From: Zac Denton
Sent: 05 May 2020 11:43
To: 'East Preston Parish Council (SC)' [REDACTED]
Subject: RE: EP/49/20/HH - 45 The Ridings, East Preston, BN16 2TW

From: East Preston Parish Council (SC) [REDACTED]
Sent: 04 May 2020 17:32
To: Zac Denton <Zac.Denton@arun.gov.uk>
Subject: EP/49/20/HH - 45 The Ridings, East Preston, BN16 2TW

REV	DESCRIPTION	DATE
PROJECT 45 THE RIDINGS EAST PRESTON WEST SUSSEX BN1 6 2TW		
DRAWING TITLE EXISTING ELEVATIONS, SECTIONS & STREET ELEVATION		
CLIENT MRS J B SHULMAN		
SCALE 1:100 @A1	DRAWN BY FLB	DATE APR
DWG NO	935/E03	REV

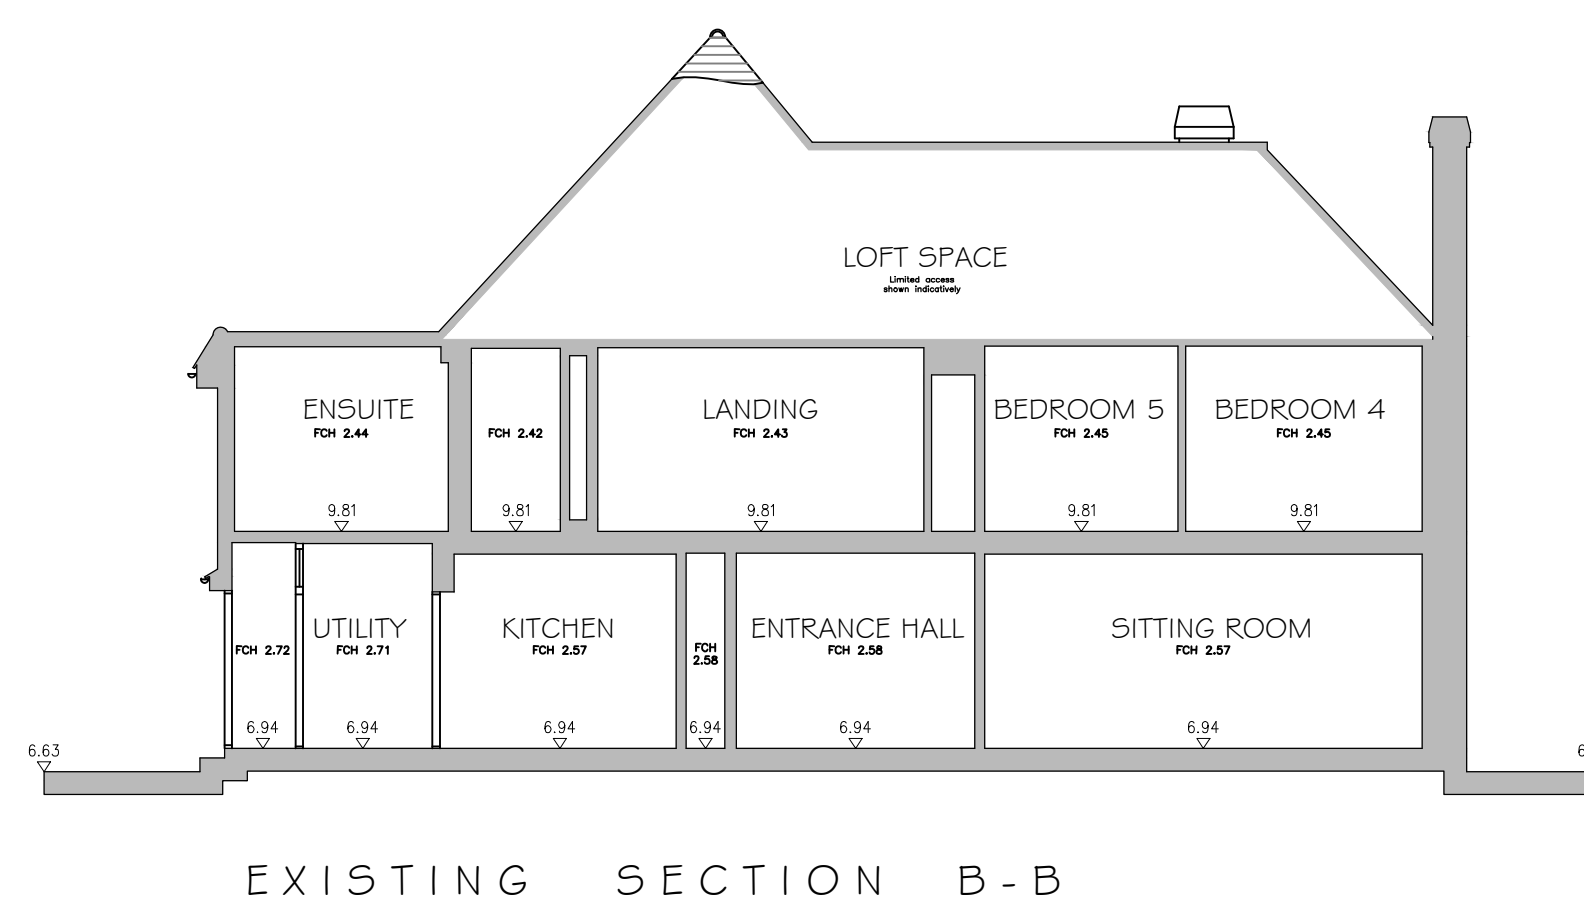
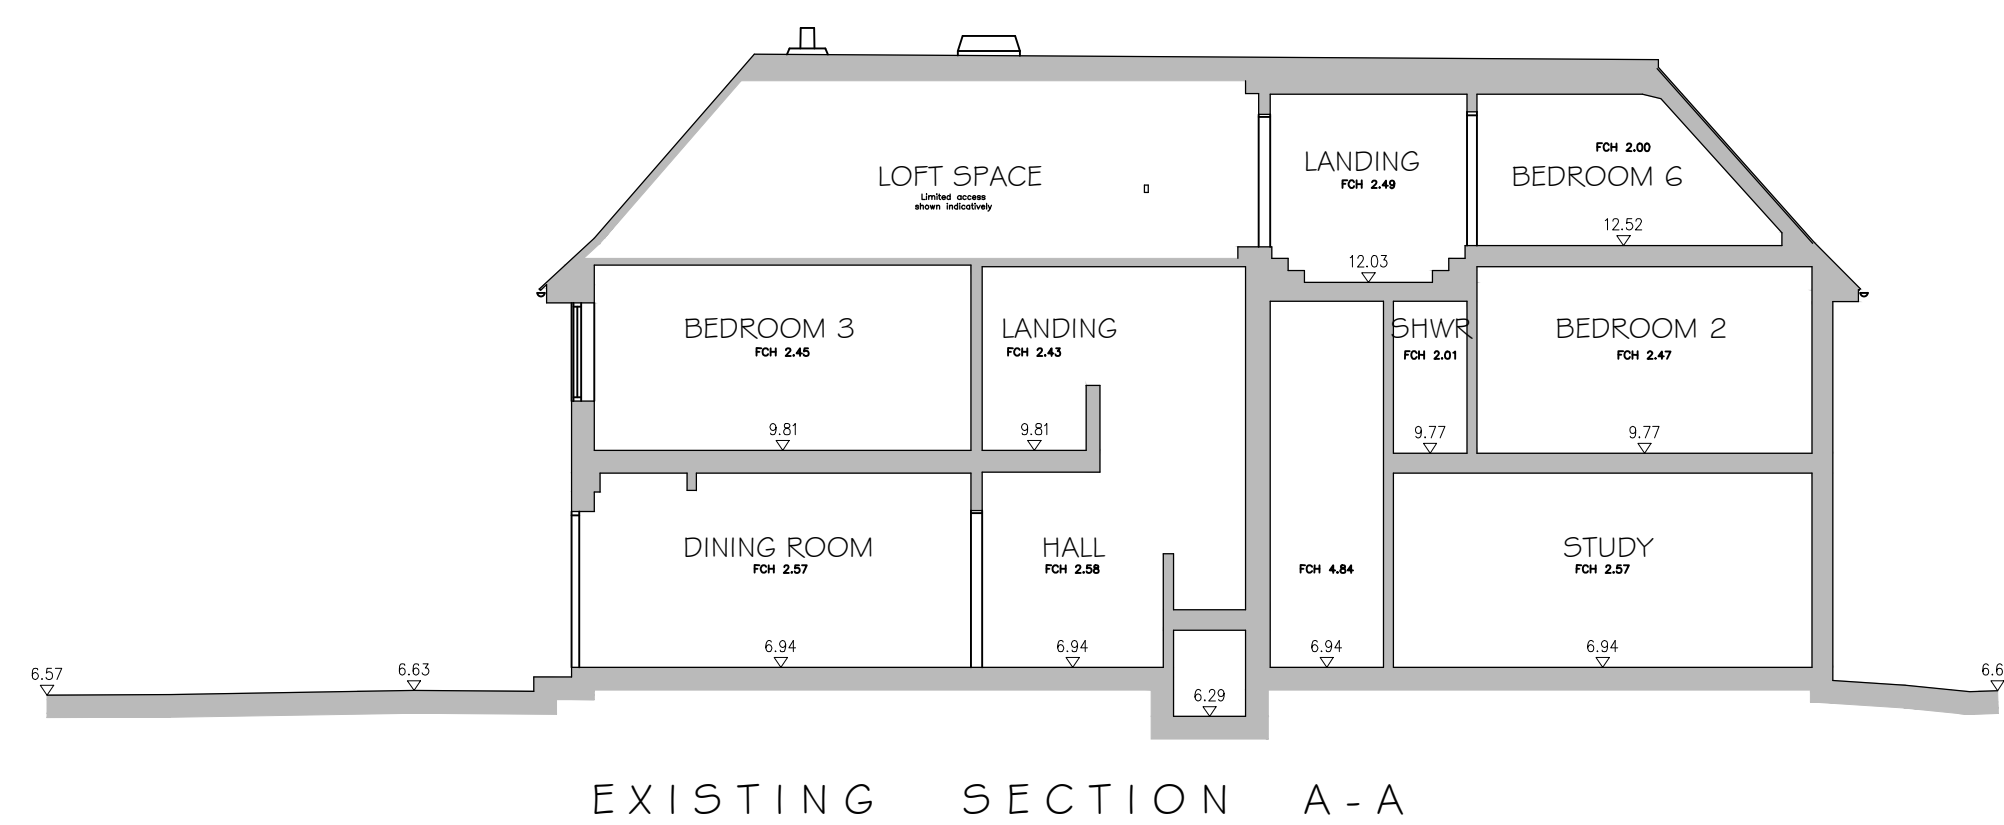
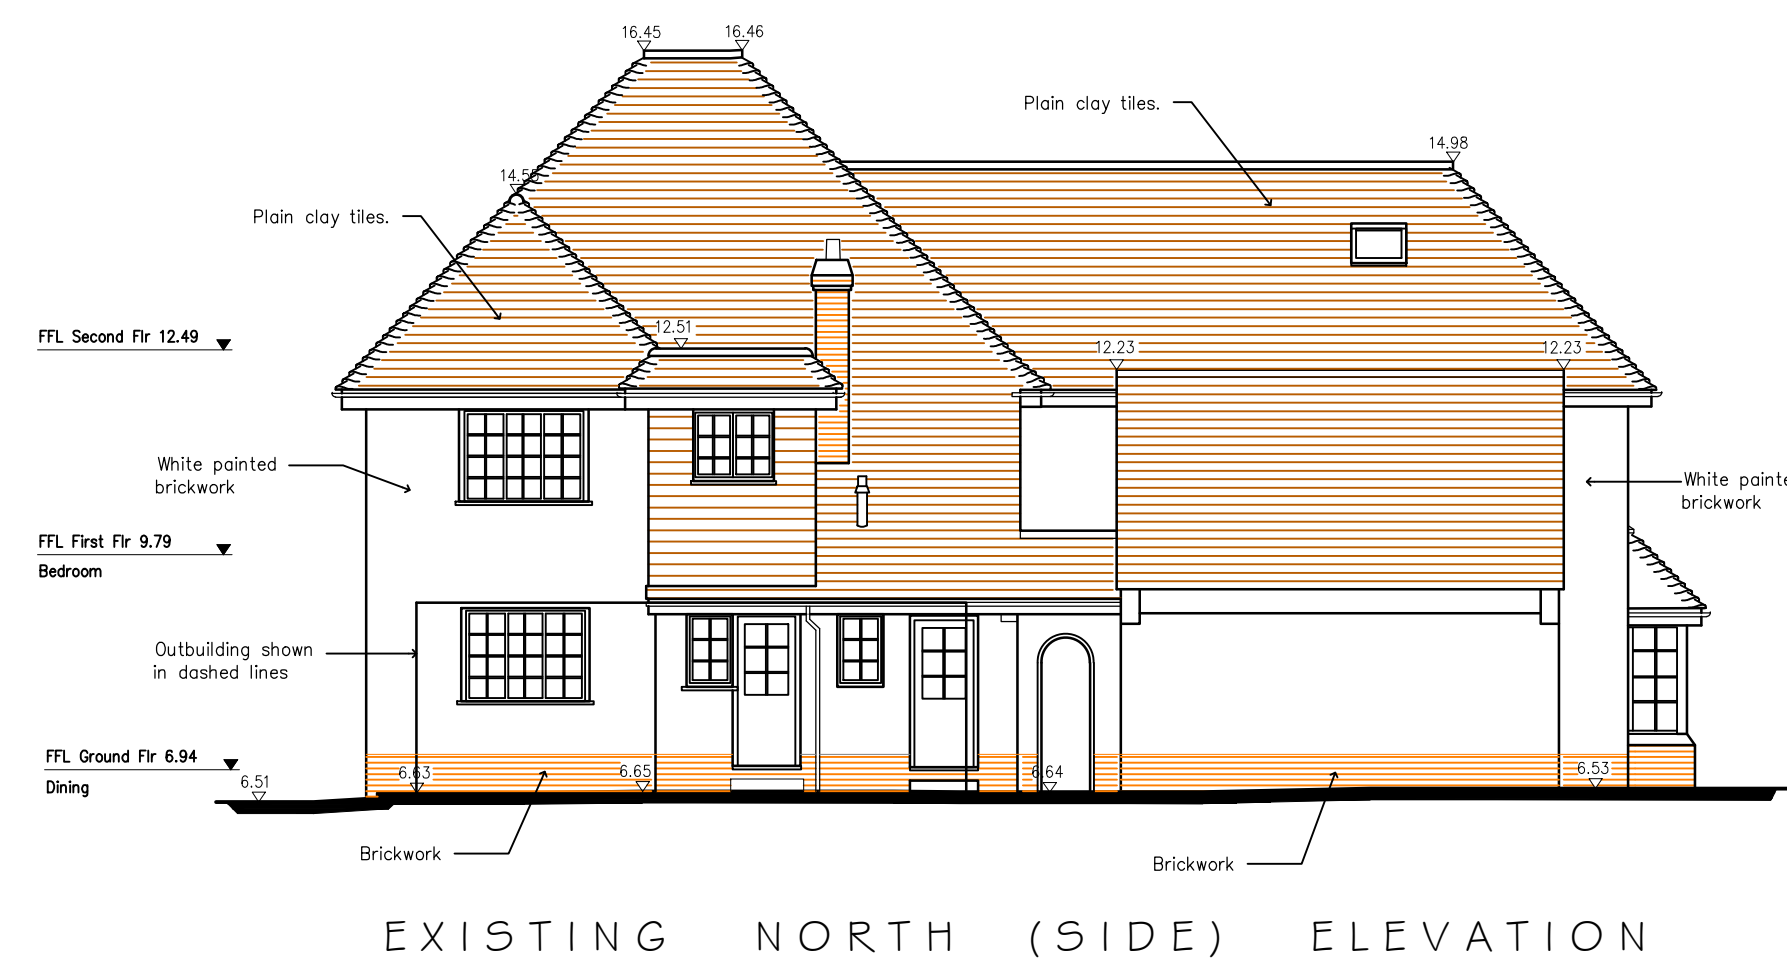
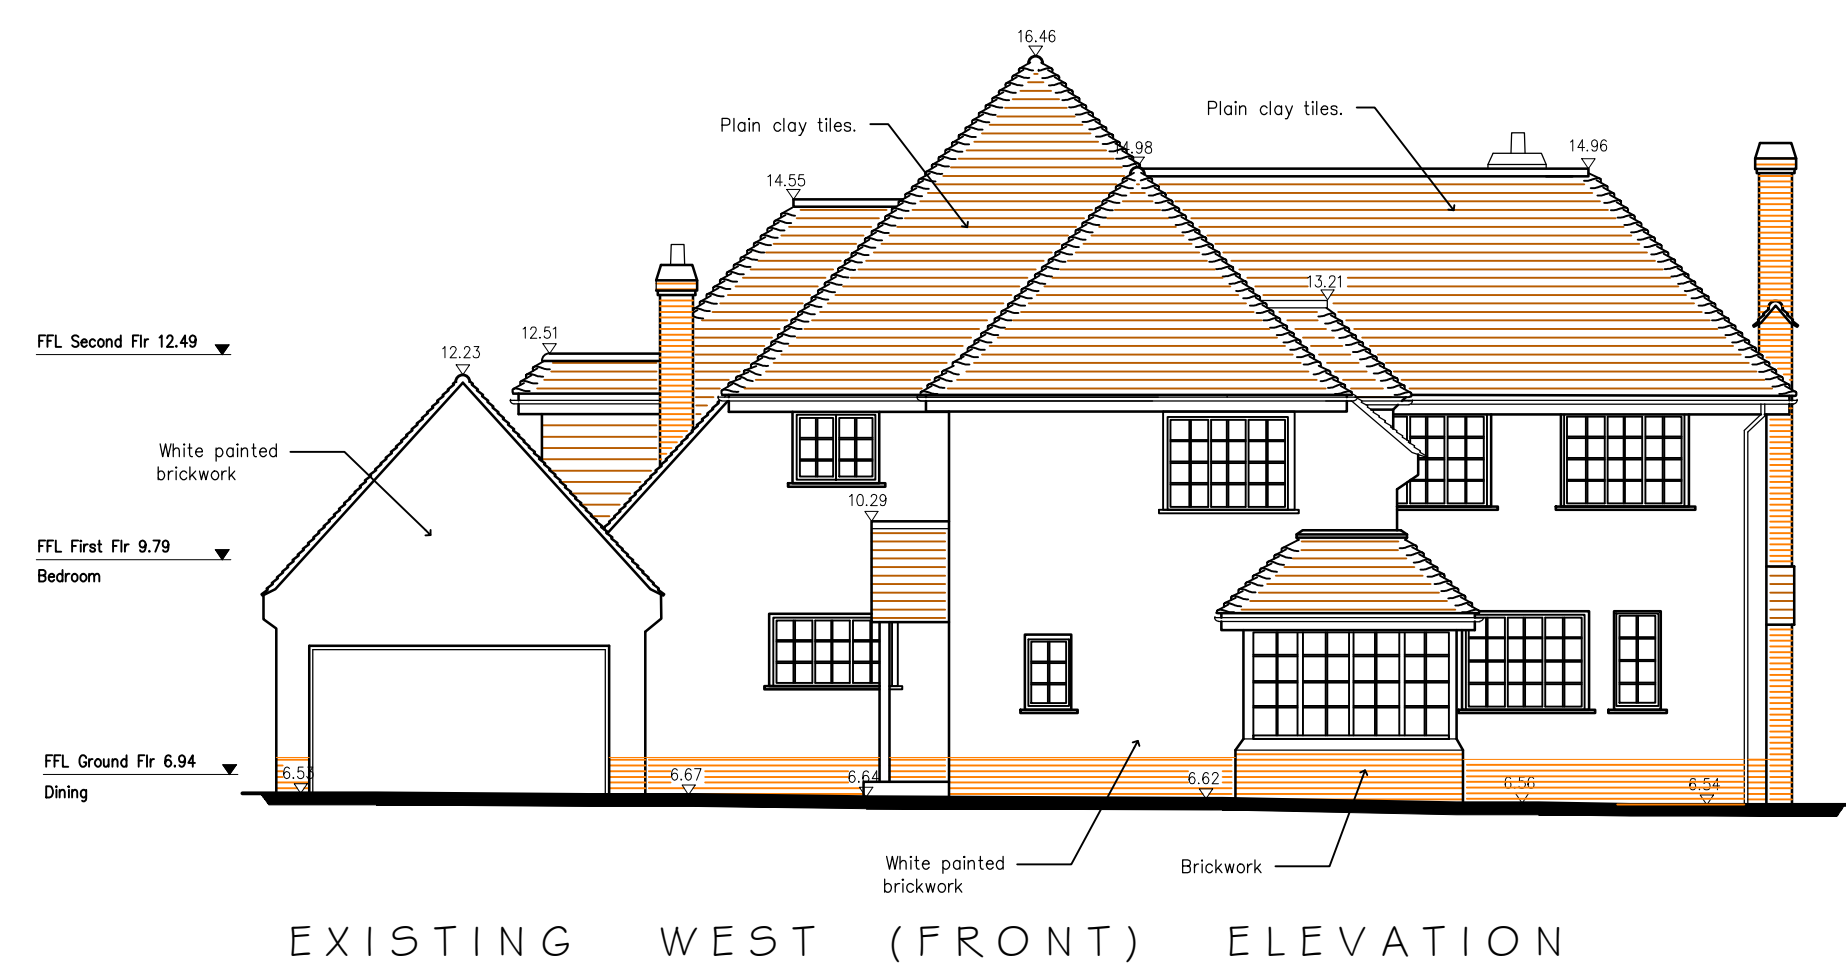
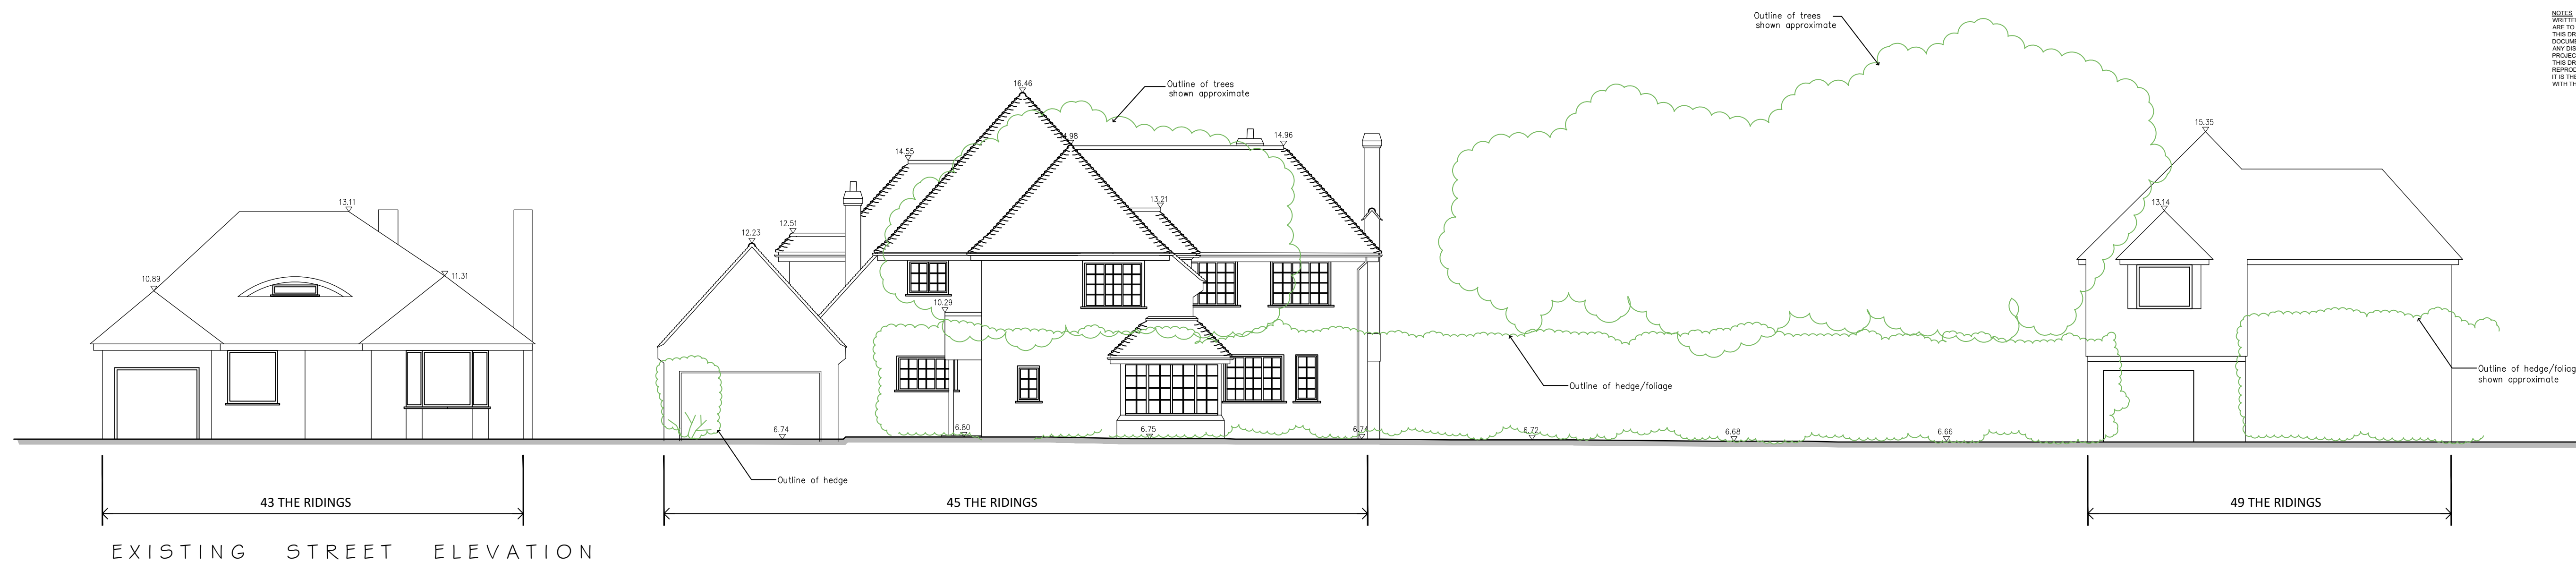
I have advised members of the public of your confirmation below. However, one has come back with the following, "Could you please request the planner to ask the architect for the ordinance data height (OD) on the proposed elevations drawings, so that it can be compared to the existing OD identified on the existing elevation drawings." Would you be able to pursue that please.

As there is no increase in height of the dwelling, the Ordinance Datum height will remain the same.

REV.	DESCRIPTION	DATE
PROJECT	45 THE RIDINGS EAST PRESTON WEST SUSSEX BN16 2TW	
DRAWING TITLE	PROPOSED ELEVATIONS & STREET ELEVATION	
CLIENT	MRS J B SHULMAN	
SCALE	1:100 @A1	DRAWN BY FLB
DWG NO	935/P07	DATE APR 20
		REV. -

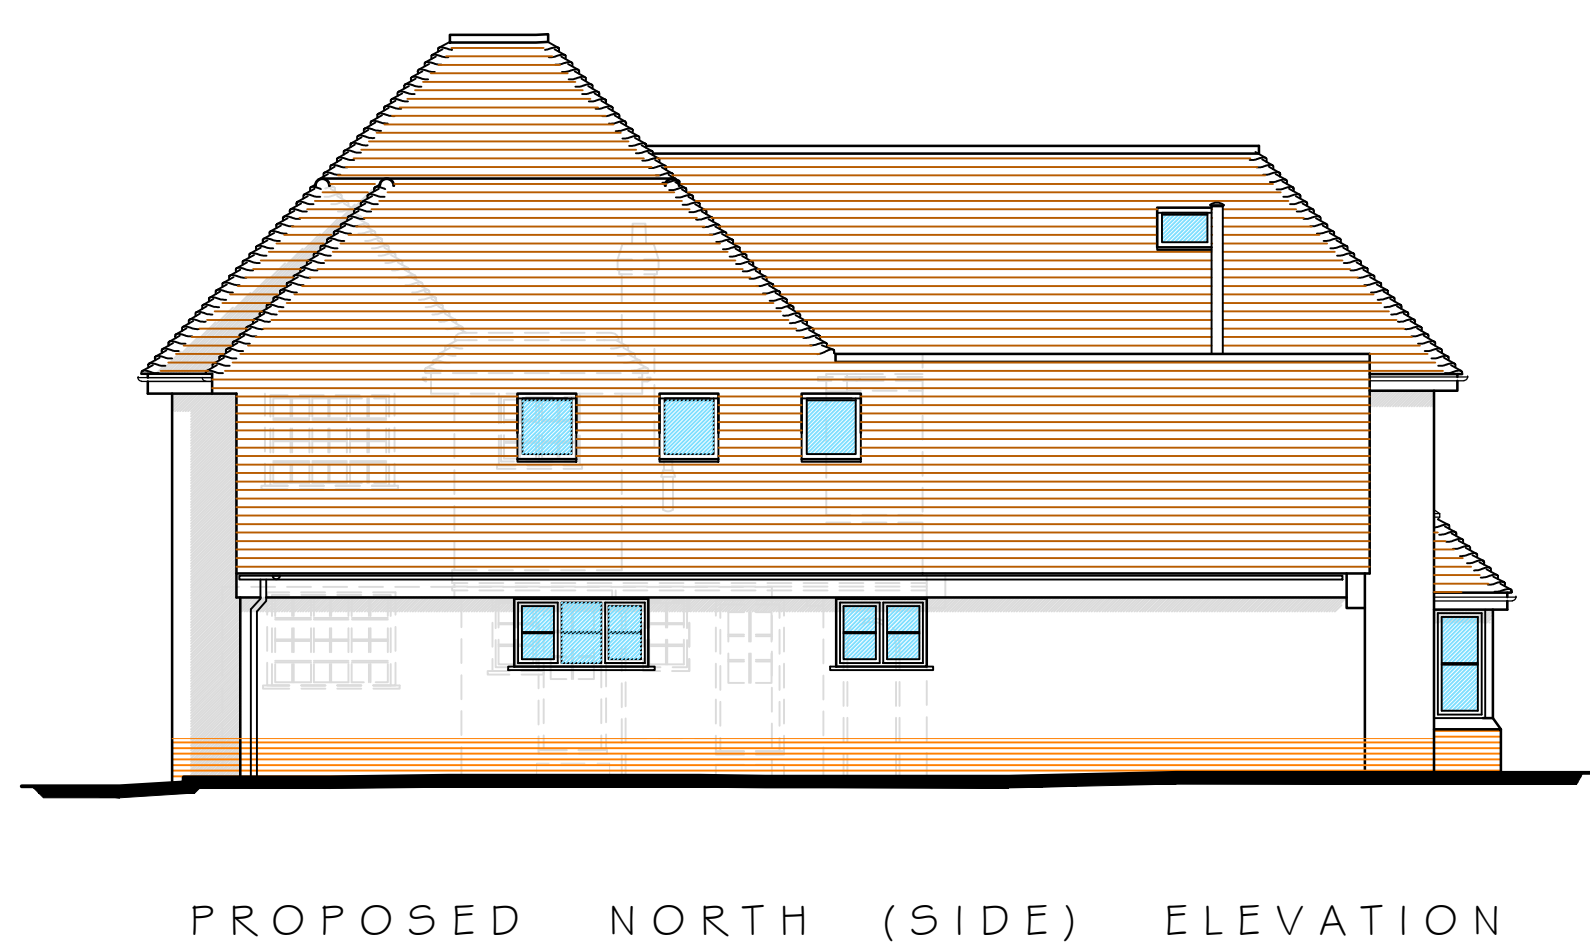
We have had a few local residents say they cannot tell whether or not the height of this property will increase in the redevelopment. To my inexperienced eye, I think it will remain the same height but please could you confirm with your more expert eye or via the agent?

Very kind haha! I have looked over the plans and it does not appear that there will be an increase in height of the dwelling.
